Subject: CM/14/20/DOC - Kents Barn, Brookpit Lane, Climping

With regard to the landscaping condition (13) the application requires further information to be shown comprising the following:

LANDSCAPING SCHEME 1:200@A2

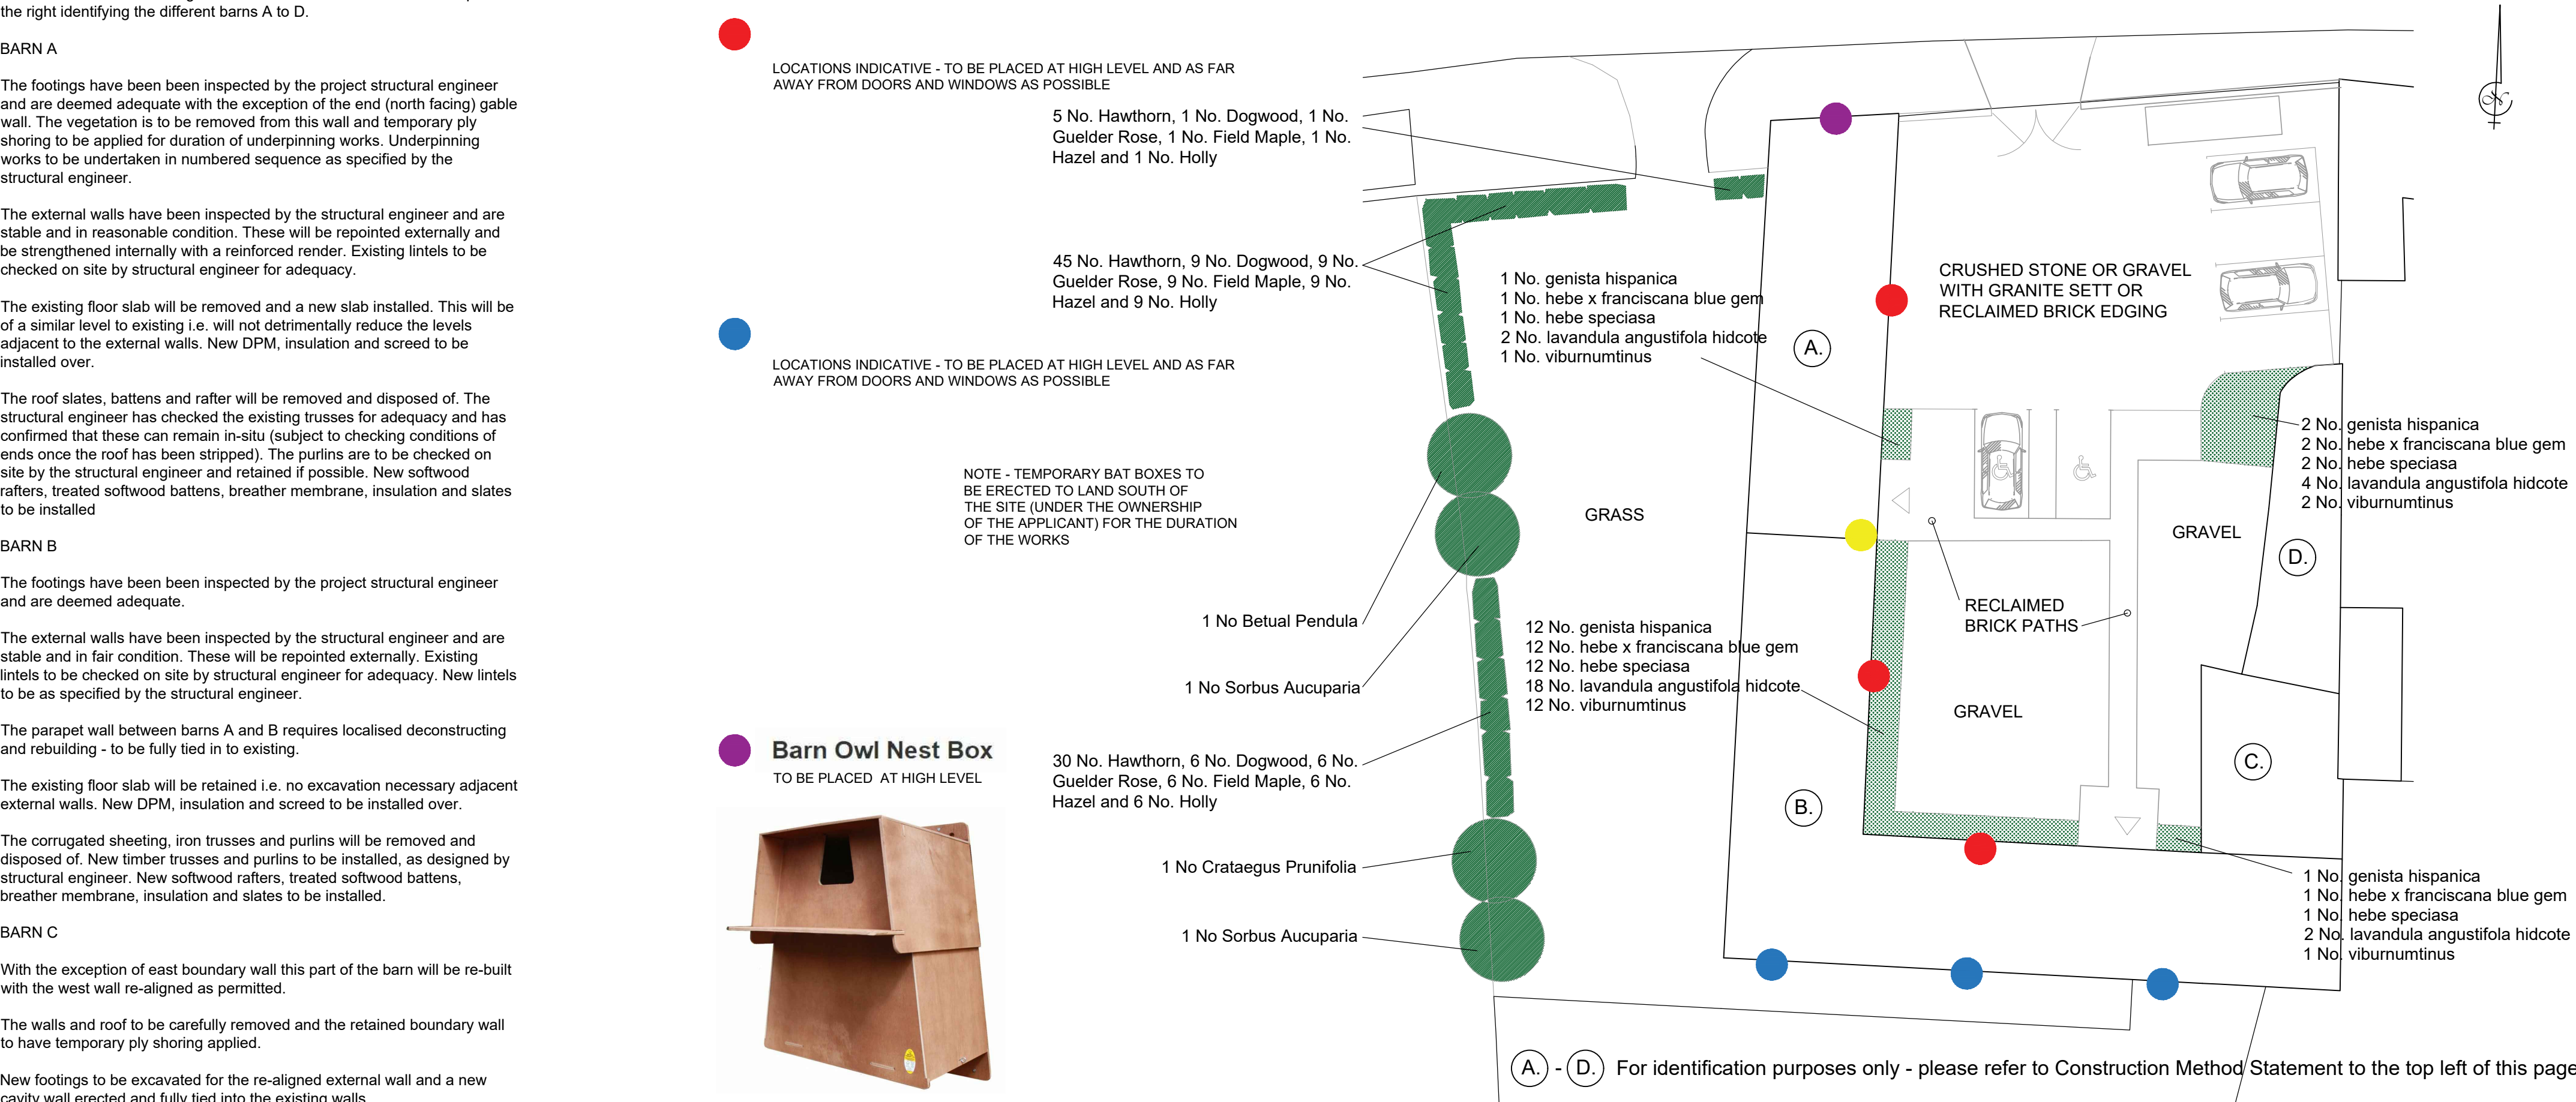
- Actual quantities to be provided in location for the shrubs and hedging proposed and which trees going where for the trees indicated, shown also on the plan.
- Please can this information be submitted in plan form. This can be hand annotated onto the plan 1169/Figure 1 Rev 2.
- I would appreciate receipt within the next 10 days.
